Addendum #1

**The Parkside Neighborhood Center
and Affordable Housing
Mellen & Grant Streets,
Portland, Maine 04101**

February 12, 2004

BUILDING A
A3.2

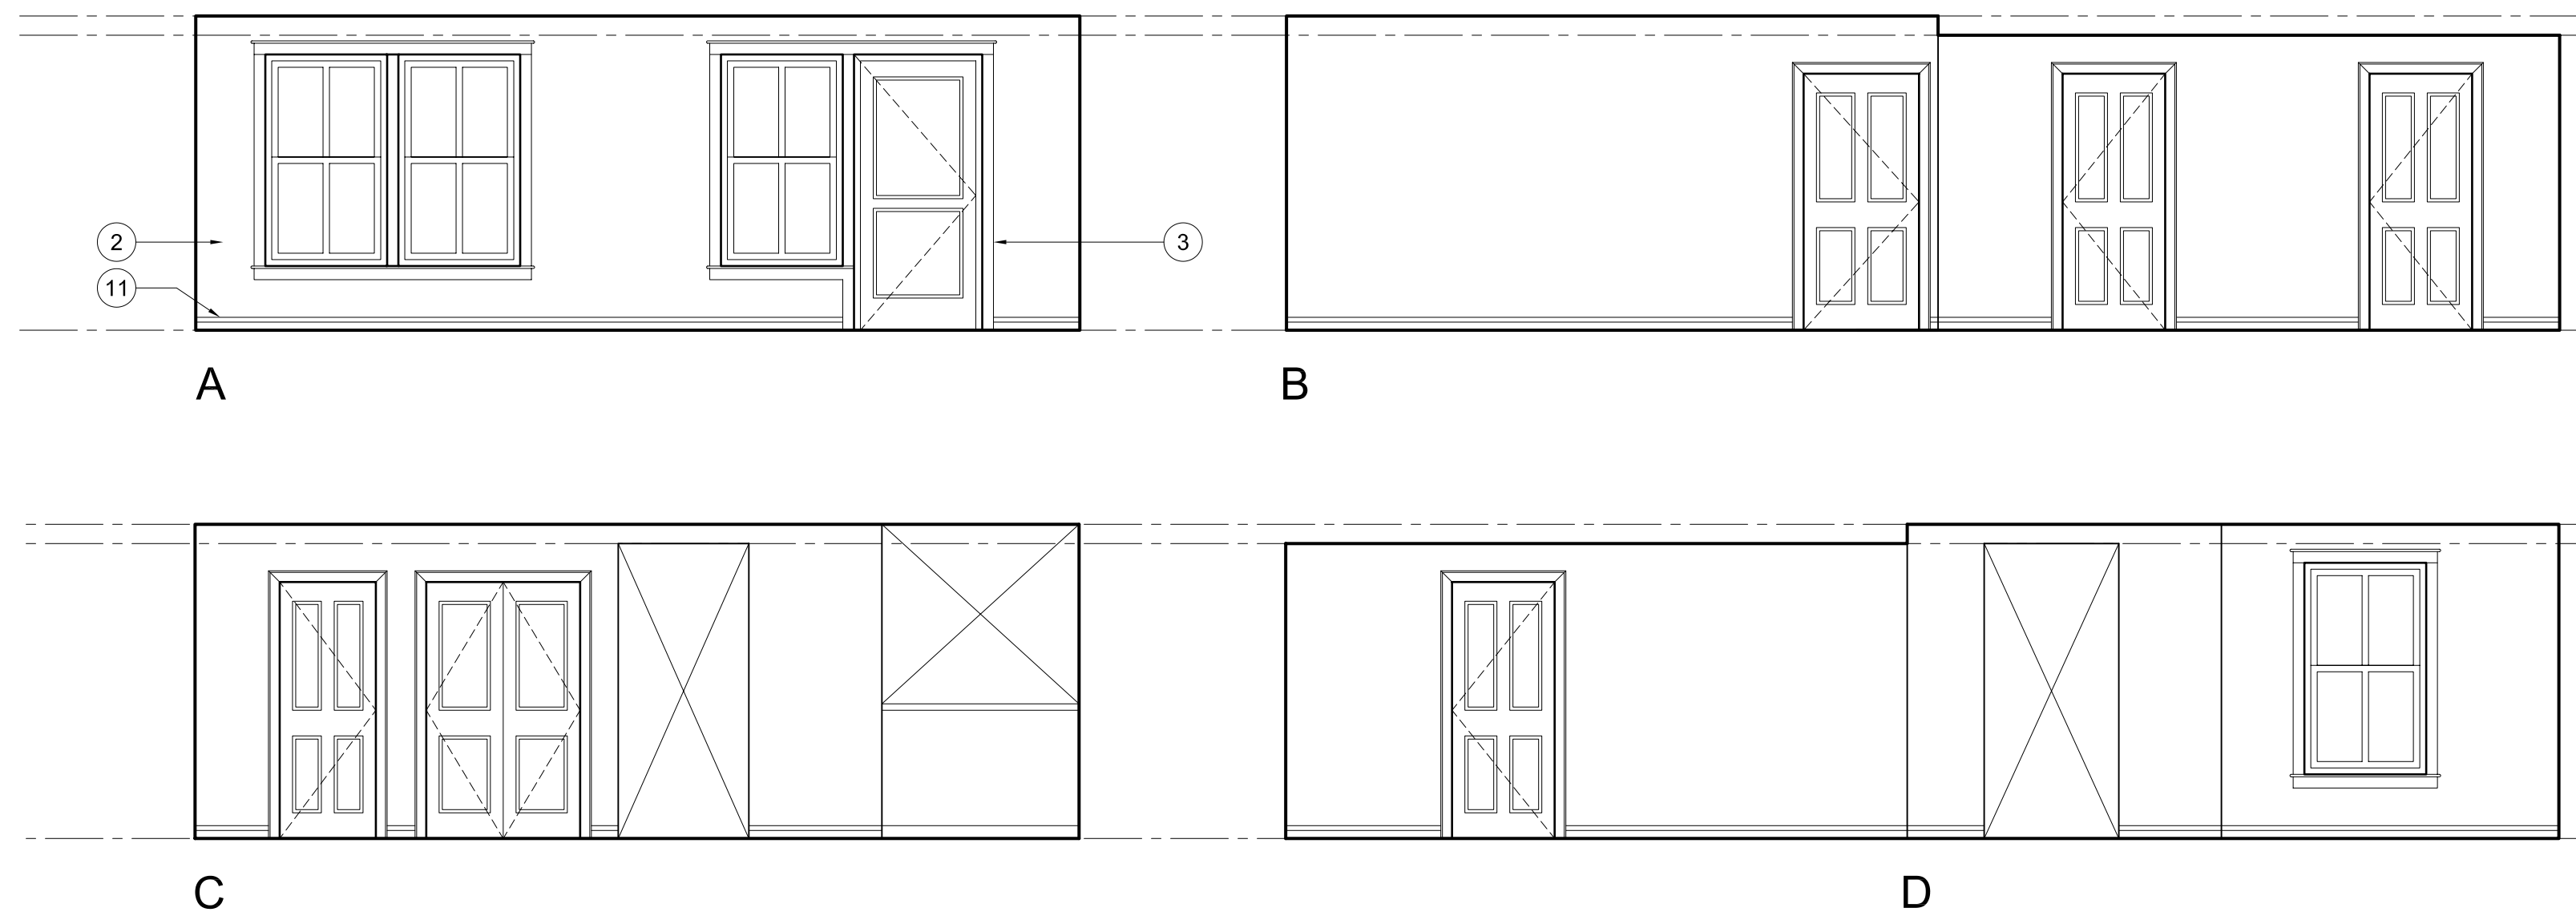
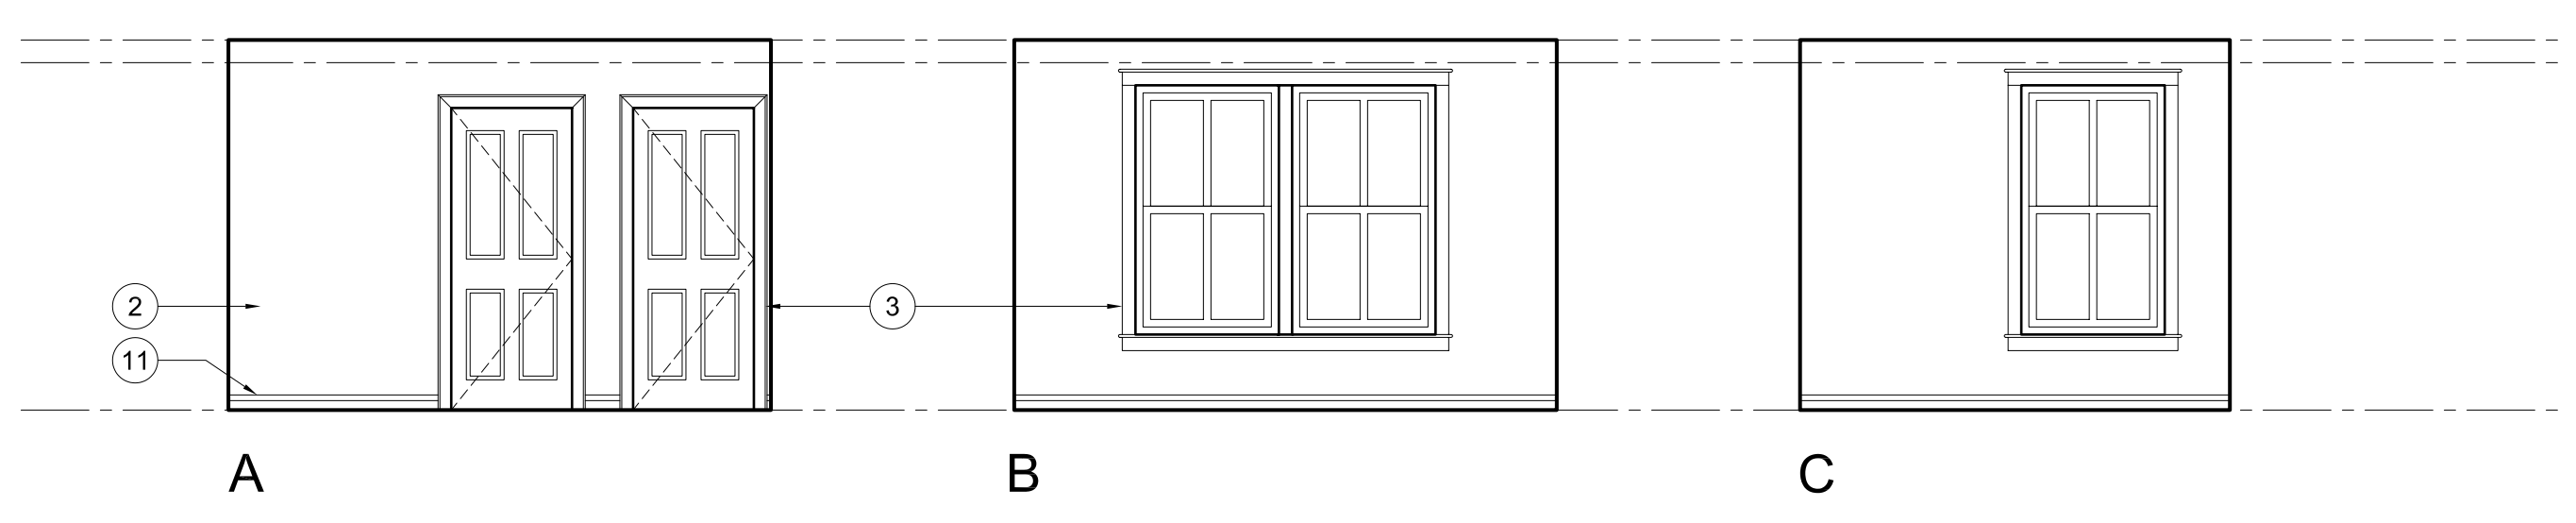
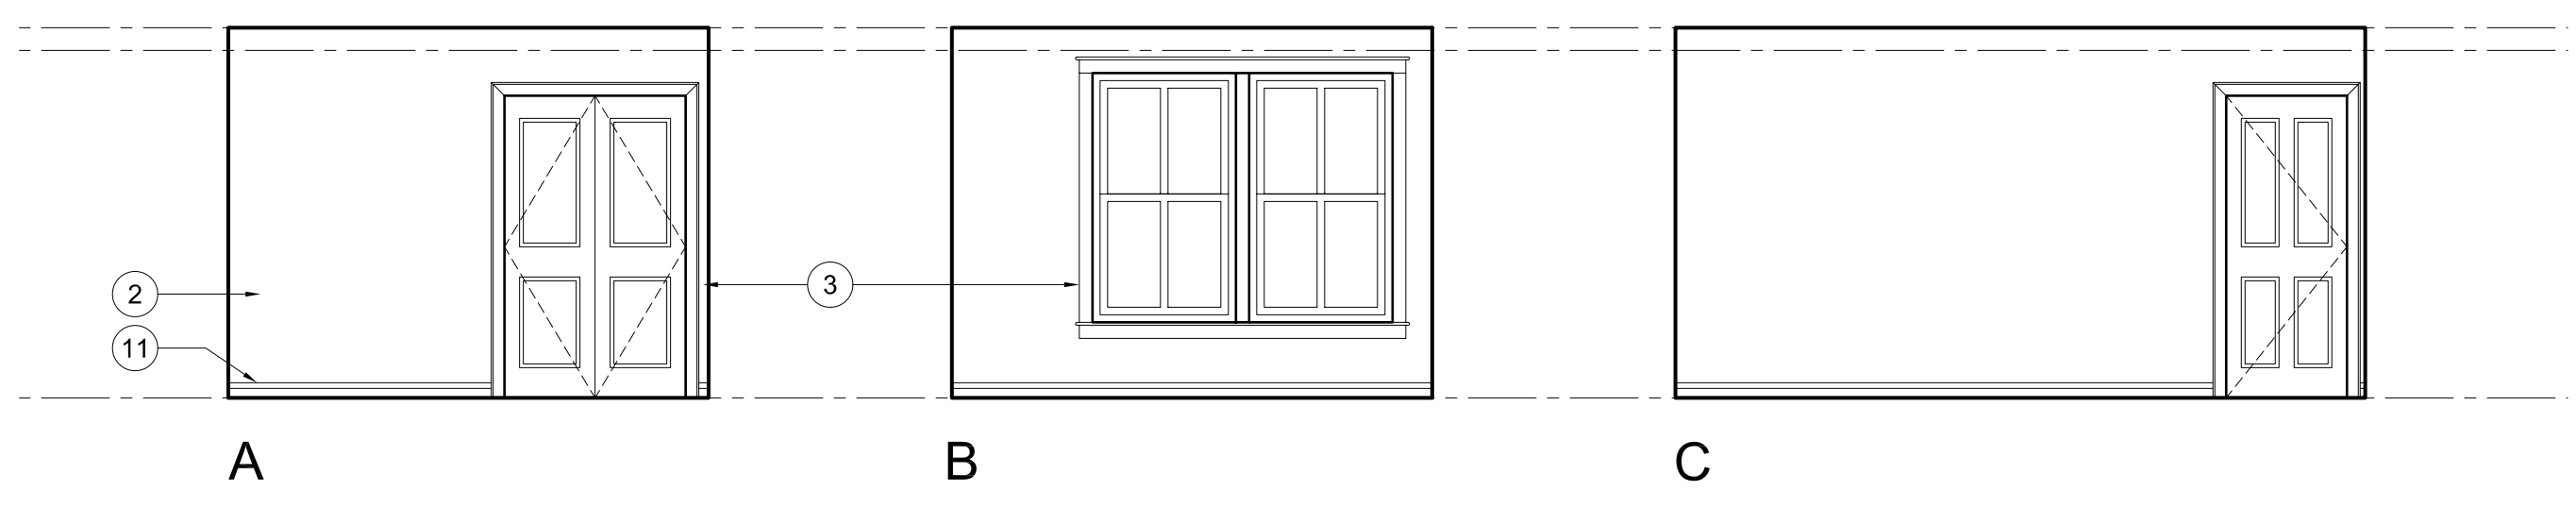
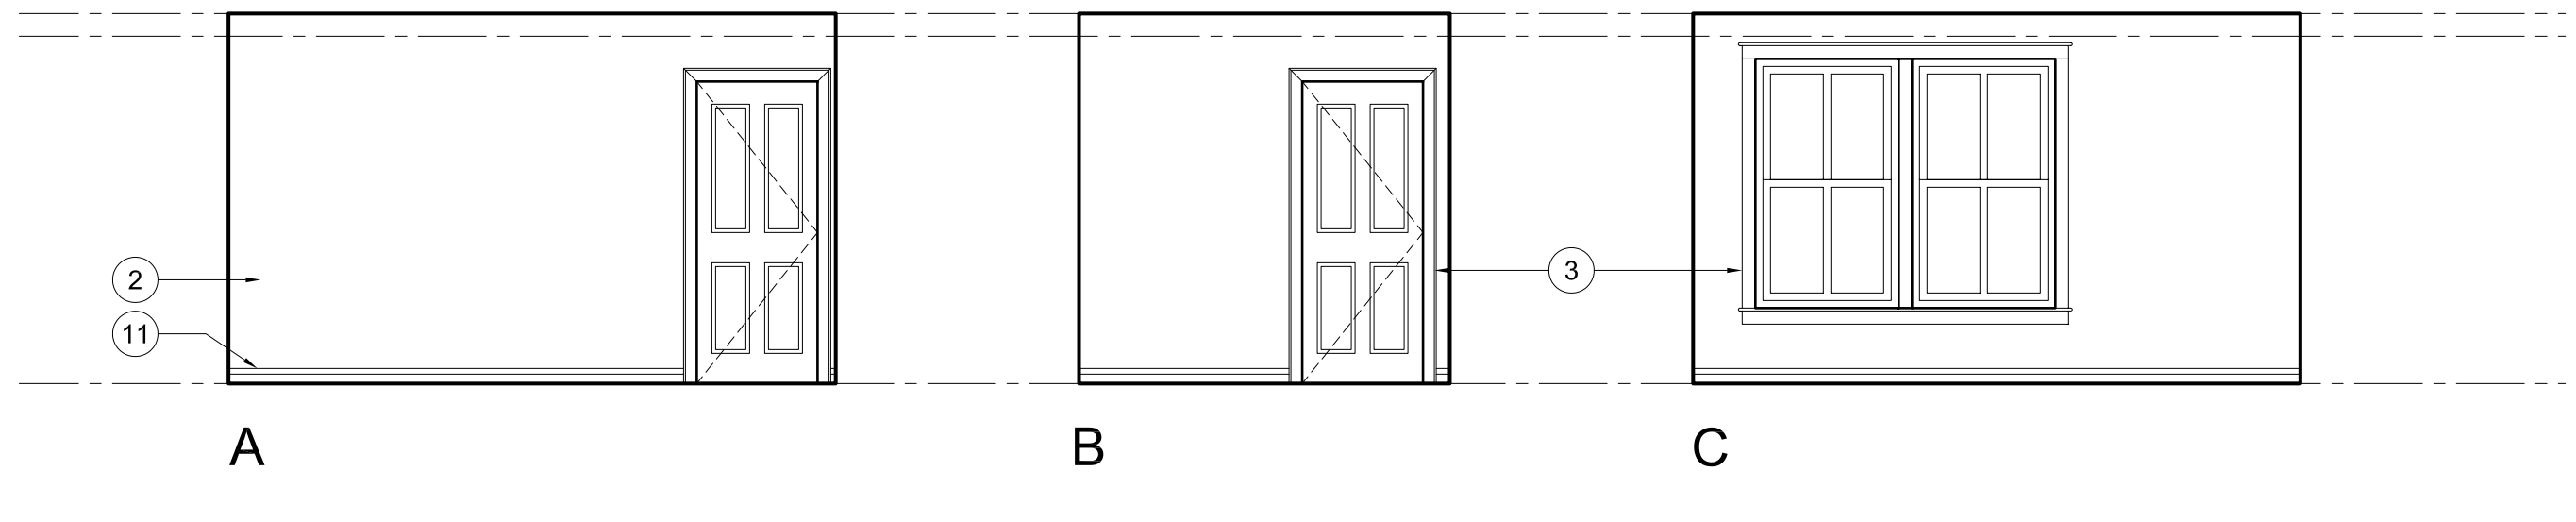
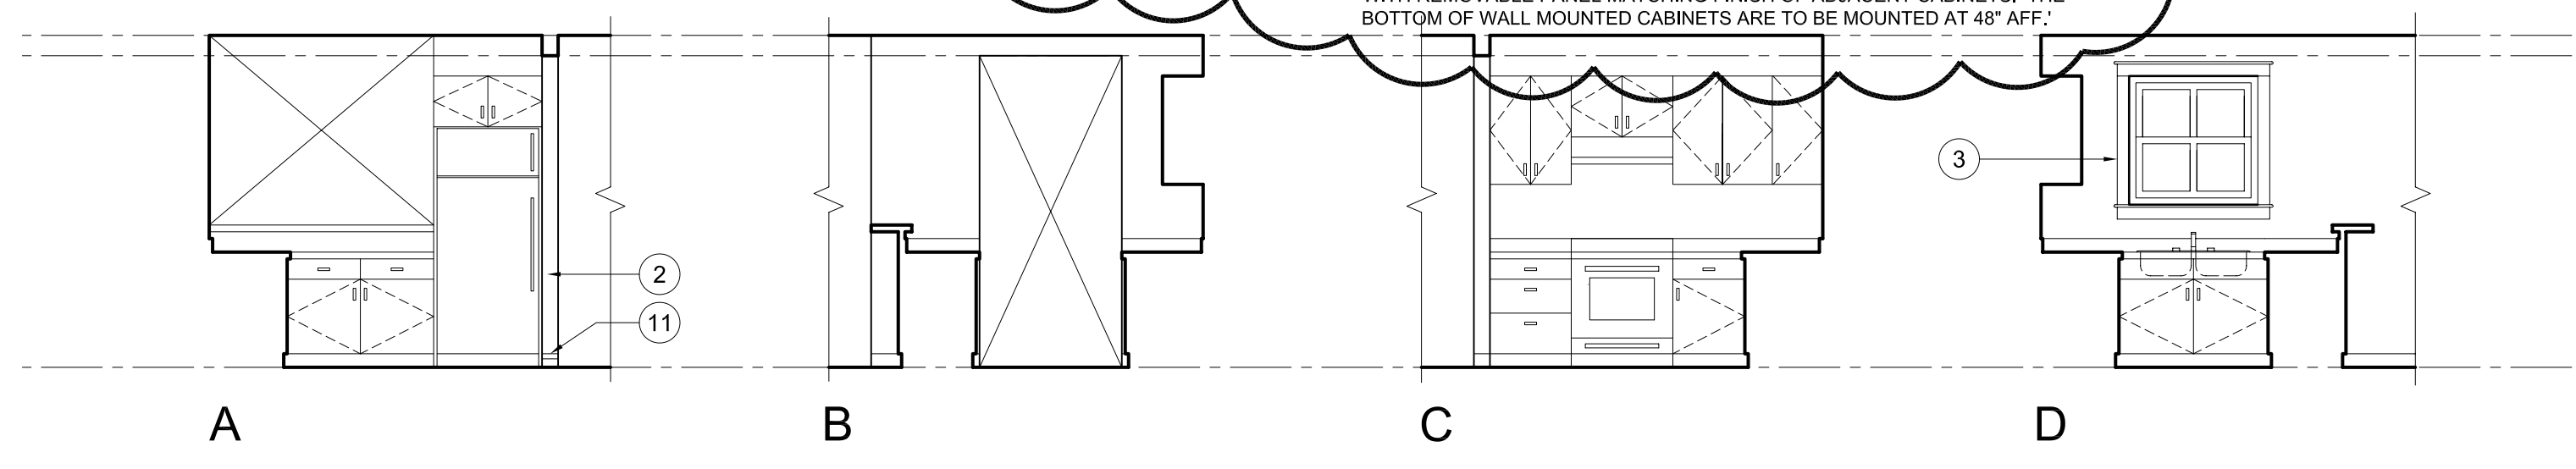
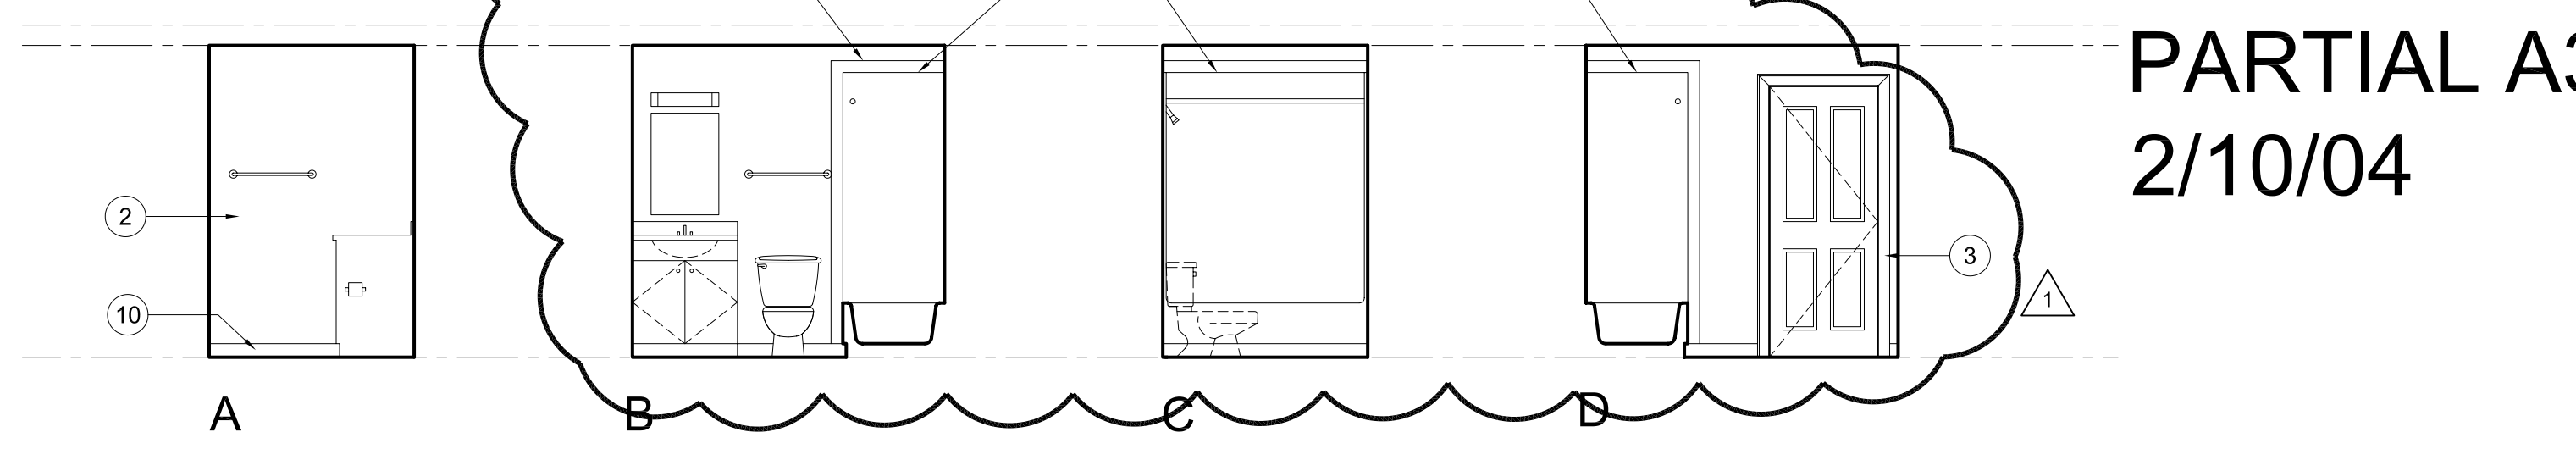
Typical residence unit interior elevations are shown on Sheet A3.2 Bldg A. These are intended to cover the range of interior conditions for all units in Buildings A & B. Unique conditions are called out in respective plans and reflected ceiling plans or similar interior elevations as required. Sub contractors are to coordinate plans, reflected ceiling plans, schedules and typical unit elevations for the appropriate scope of work.
